KIRKLEES METROPOLITAN COUNCIL INVESTMENT & REGENERATION SERVICE

DELEGATED DECISION TO DETERMINE APPLICATIONS FOR CONSENT, AGREEMENT OR APPROVAL REQUIRED BY CONDITION

Reference No:	2026/44/91599/E
Site Address:	Wesley House, Huddersfield Road, Birstall, Batley, WF17 9AZ
Description:	Discharge of details reserved by conditions 3 (roof light), 8 (bin store), 9 (lighting), 10 (bat box), 11 (Construction Management Plan - Gravestone) on previous permission 2024/92105 for alterations to convert former offices to 21 apartments (Listed Building within a Conservation Area)
Recommending Officer:	William Simcock

DECISION – Discharge of Condition – Approve

Drawing No: KL/24/1709/21	Scale: 1:50 @ A1	Date: July 2025
------------------------------	---------------------	--------------------

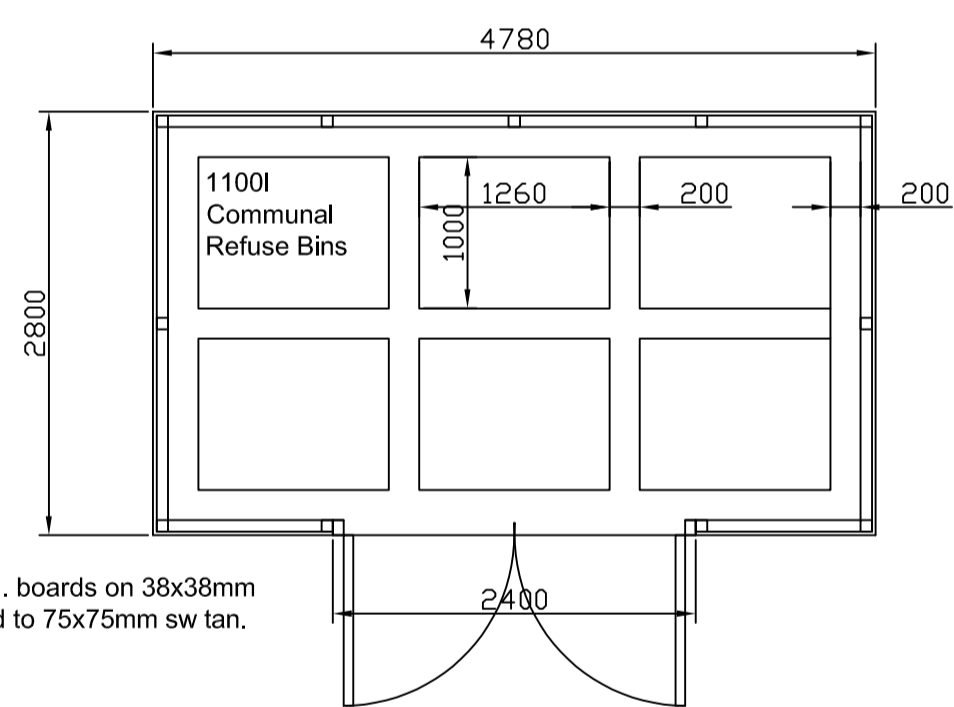
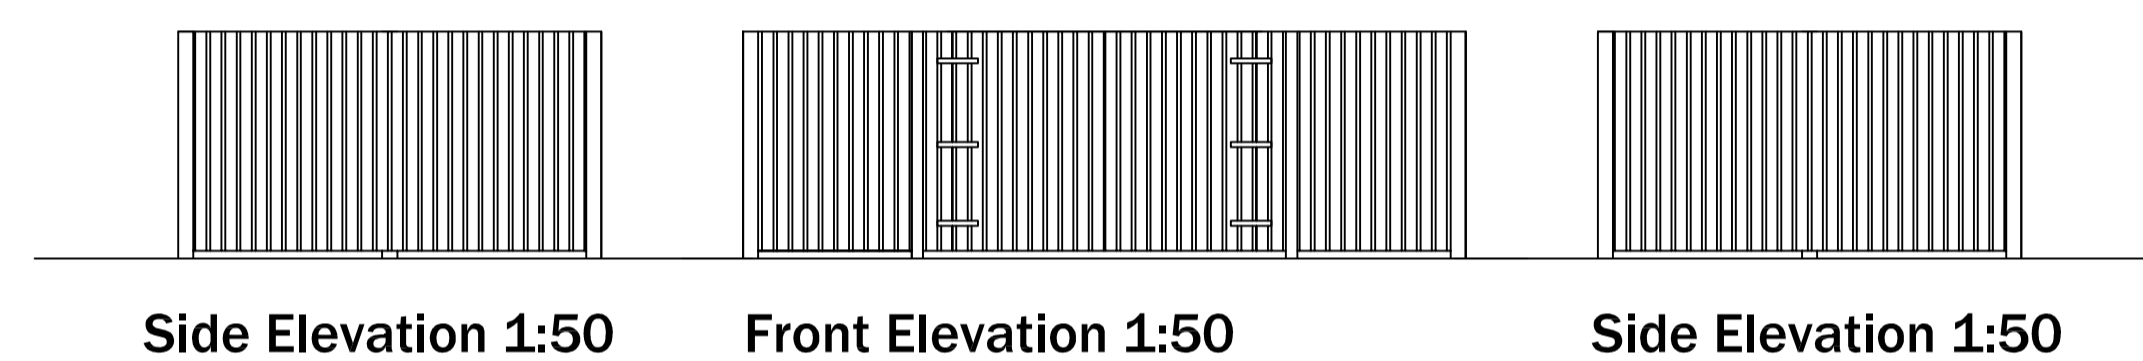
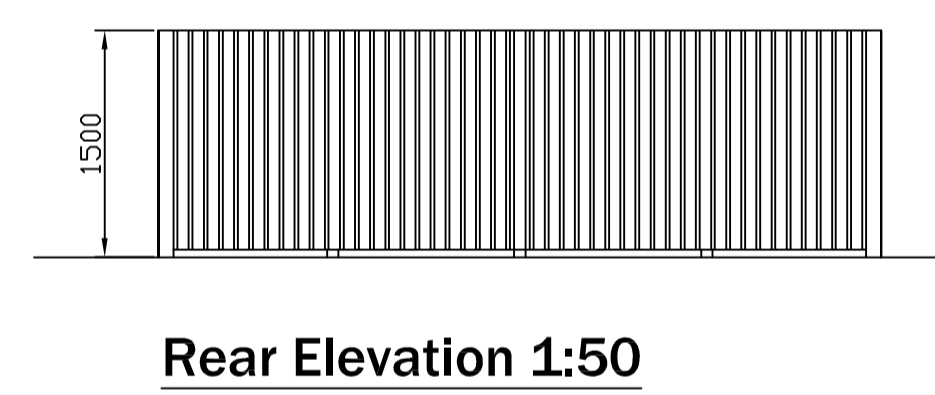
- A plan, titled Bin Store Detail, reference KL/24/1709/21. This shows the plan of a refuse compound of 4.78m by 2.80m, with a height of 1.5m, which would hold 6 no. communal refuse bins each with a capacity of 1,100 litres. An annotation states that the enclosure would be built of softwood tanalised boards and fixed to timber posts.

KC Waste Strategy were consulted, and in their comments of 30/06/2026 advised that the arrangements were unacceptable for three reasons:

- The bin store is undersized and must allow for a footprint of 1575mm x 1190mm plus internal access for future users and collection crews;
- The bin store is too far from the adopted highway – it should be within 8m, or alternatively responsibility for moving the bins to a collection point must be clarified;
- The vehicular entrance to the site is too steep for the safe manoeuvring of bins. Gradients should not exceed 1:12.

A subsequent amendment (rev KL/24/1709/01E, 31/07) showed the bin store adjacent to the building. KC Waste Strategy, in informal comments of 31/07/2026, advised officers that this would be unacceptable for fire safety reasons. Furthermore, the size and internal layout of the bin store would not provide the internal access that would allow residents to easily reach bins at the rear of the compound, and would therefore lead to a risk of wastes being placed in the wrong bin.

Subsequently, the following amended drawings were submitted, 06/08/2026:

- Proposed site layout and location plan, ref. KL/24/1709/01F;
- Bin Store Detail, ref. KL/24/1709/21A

The wording of the condition specifically seeks details of “storage, bin presentation points and access for the collection of wastes.” The latest version of the layout shows a bin compound located in the northern corner of the site adjacent to the boundary of the public highway and a pedestrian accessway which is also within the site boundary. It does not show a designated collection point, and it is therefore implied that bin collection crews would collect directly from the bin store. The distance between the furthest bin and the nearest point on the carriageway would be approximately 7m, which is within the maximum drag distance referred to earlier in this report and therefore acceptable. Assuming that both the entrance gates at the site boundary with the footway and the gates to the bin store were kept unlocked, then there would be no difficulty in bin collection crews gaining access. KC Waste Strategy confirmed, in informal comments made 07/08/2026, that the latest drawings are acceptable.

**Planning Approval Ref :** 2024/62/92105/E  
**Condition 9 – External Lighting**

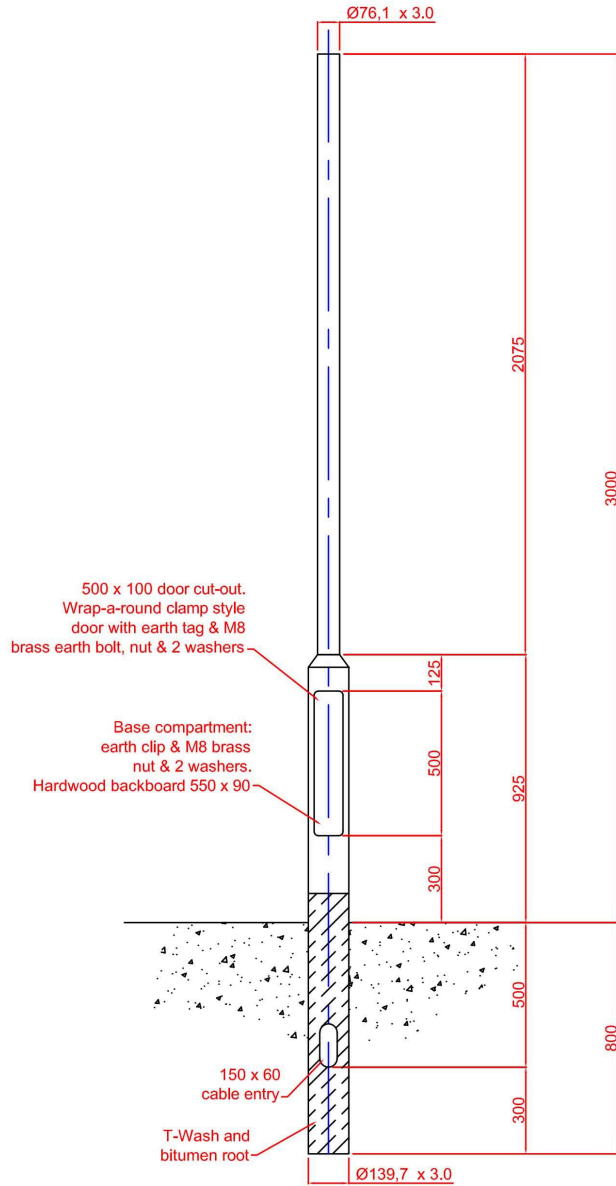
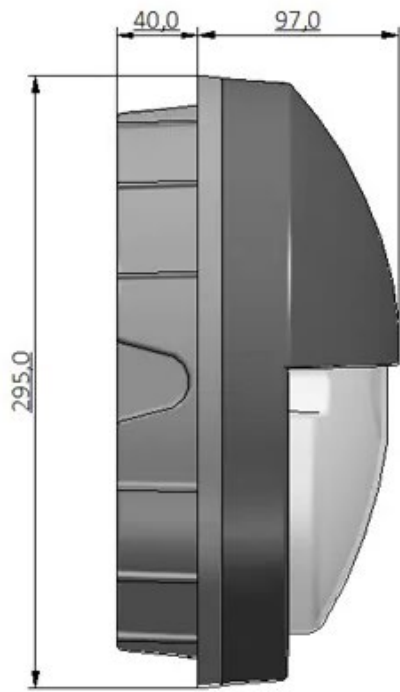
- Quantum semi-recessed anti-vandal 'eye lid' bulkhead downlight fixed to building, to avoid light pollution and to minimise effects on bats;
- 3m high column with LED Street Lantern to light downwards only to minimise light pollution and effects on bats;
- Floodlight to soffit of adjacent building.
- Illustrations and a technical drawing of the lighting column;
- A plan showing where the various types of lighting are to be installed within the site.

“The submitted information details that downlighting will be installed on the building, but does not detail where this will be installed, or what colour temperature it will be. I would recommend this information is provided, prior to discharge of condition 9.”

KC Ecology, in their updated comments (07/08/2026) confirm that the information submitted is satisfactory and has addressed their earlier concerns.

Drawing No: **KL/24/1709/01C** Scale: **1:200, 1:1250 @ A1** Date: **July 2024**

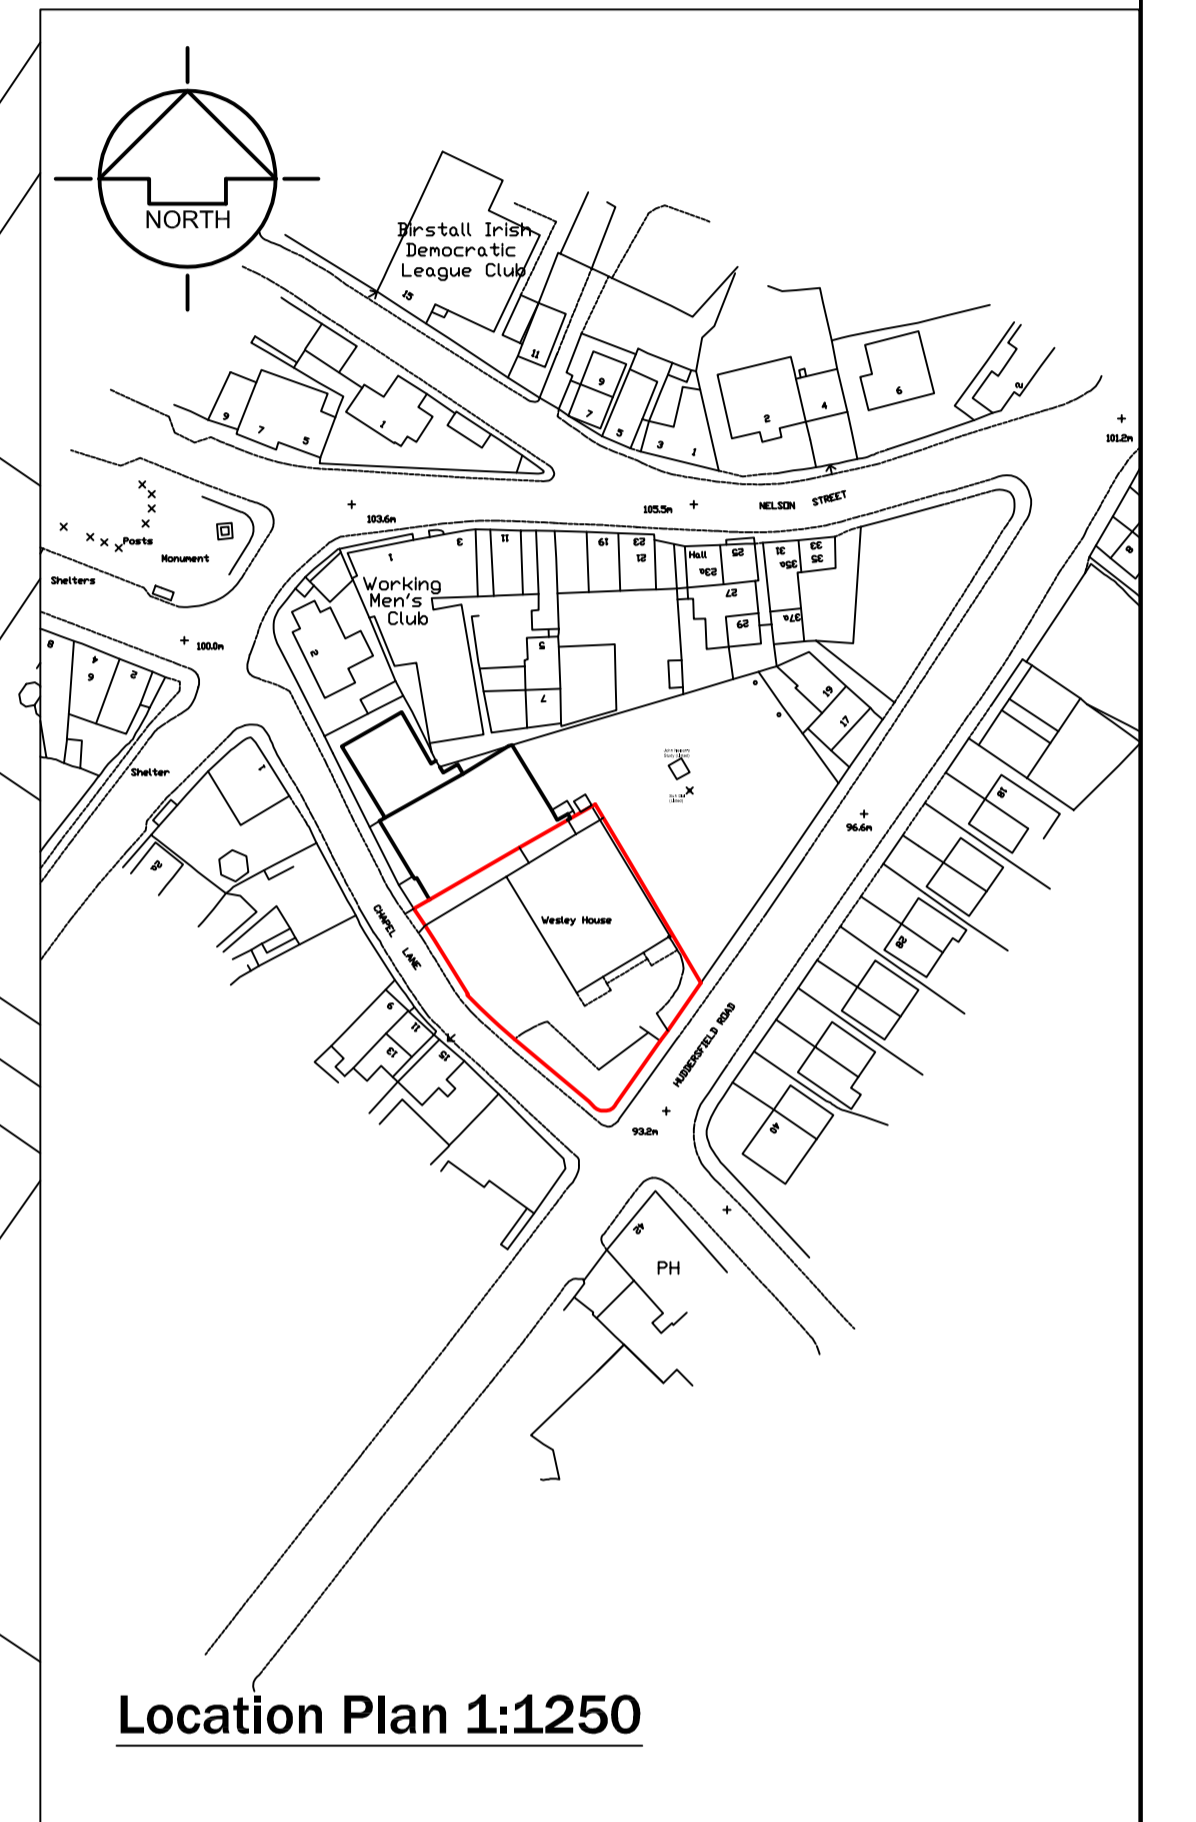
- A site layout plan reference KL/24/1709/01C, showing the location of the proposed bin store;
